Application for a non-material amendment following a grant of planning permission.

Proposed construction of 1 no. 3 bed chalet bungalow utilising existing access.

Application Ref: FG/121/09/

Change to style of window fenestration by omission of the horizontal glazing bar, addition of sidelights to the french doors to the rear (south) elevation, enlargement of the window to the side (east) elevation, change of roofing to conservatory to plain tiled roof with roof windows.

Side (West) Elevation

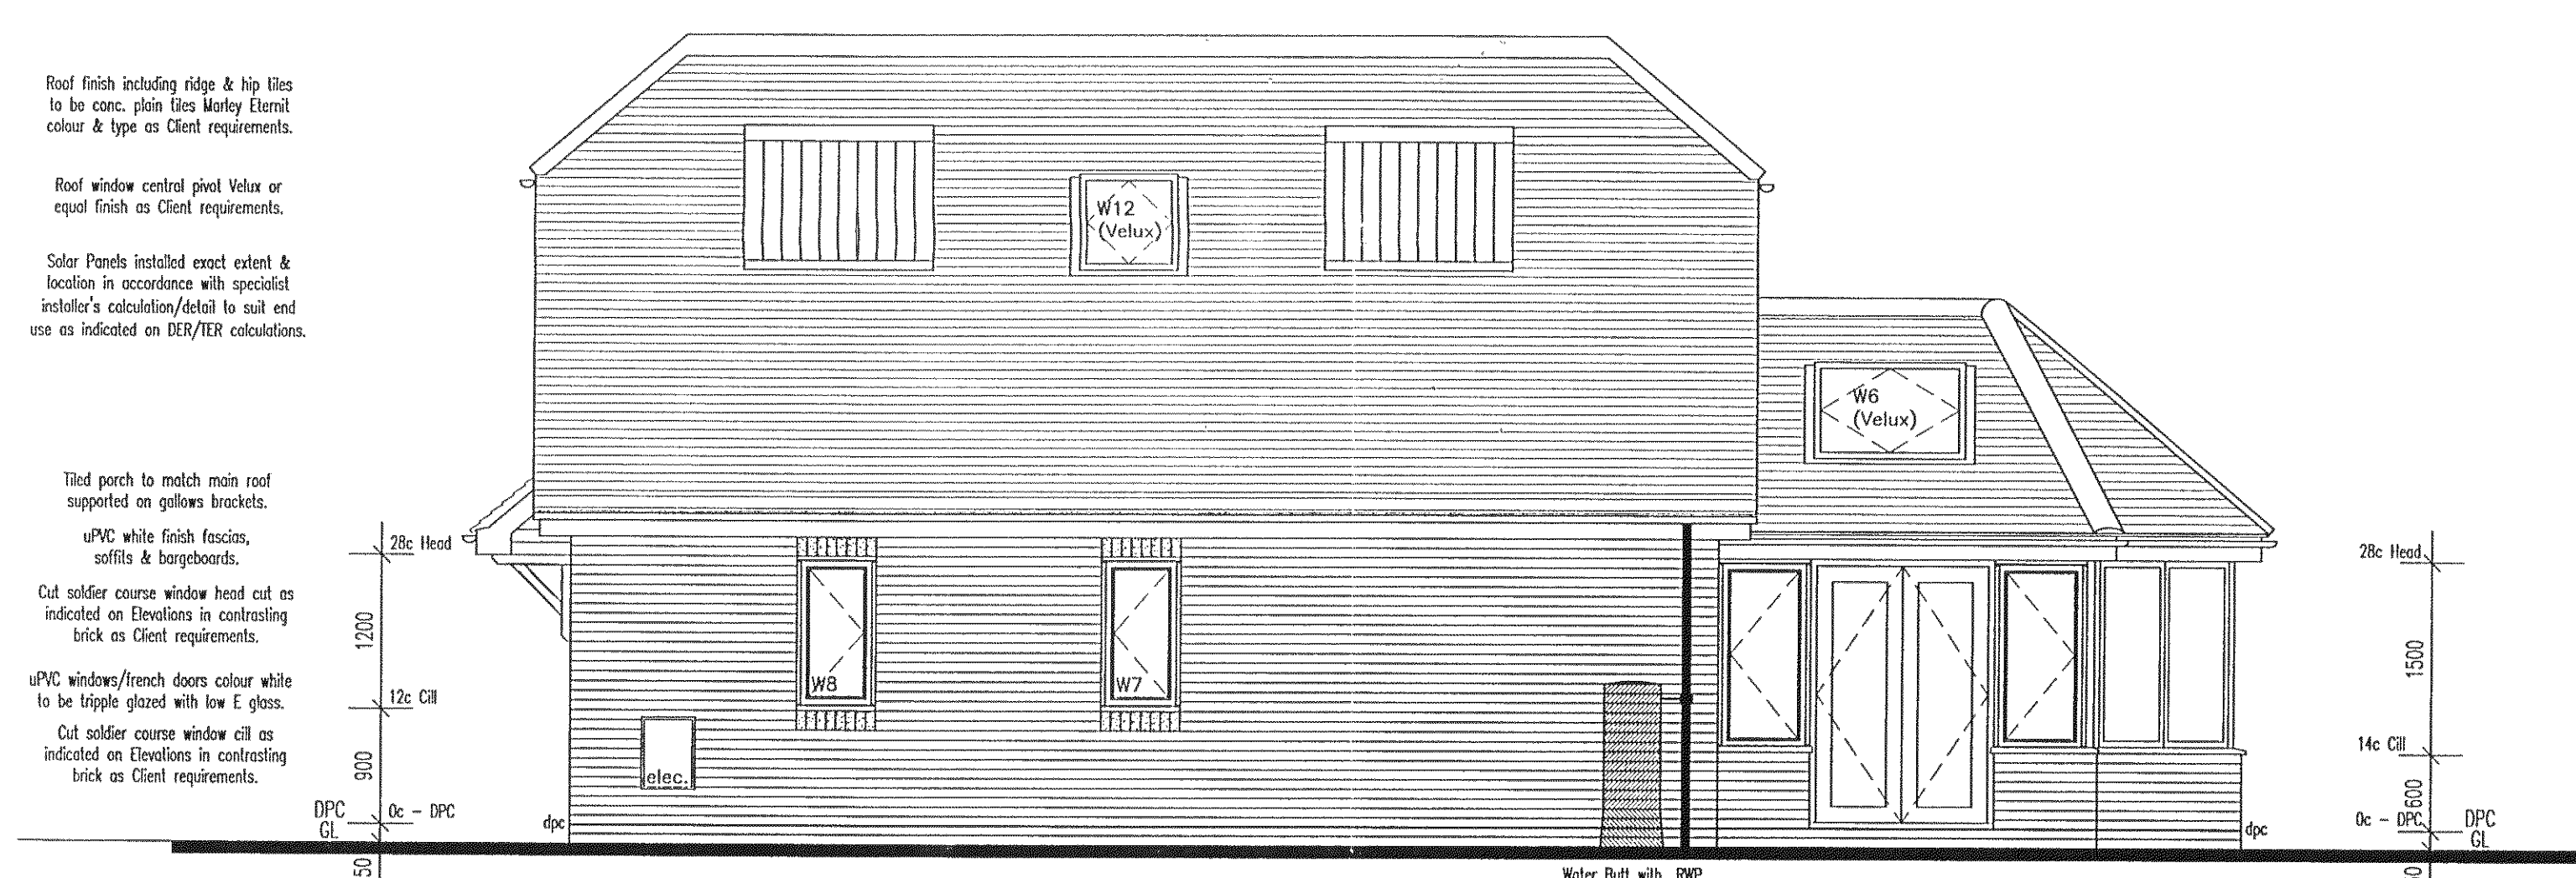
Omission of the horizontal glazing bar to facilitate use of energy efficient tripple glazing, sidelights to the french doors to the rear (south) elevation to provide room with more daylight, enlargement of the window to the side (east) elevation to provide more light to living room, conservatory plain tiled roof with roof windows to provide sun room in place of conservatory.
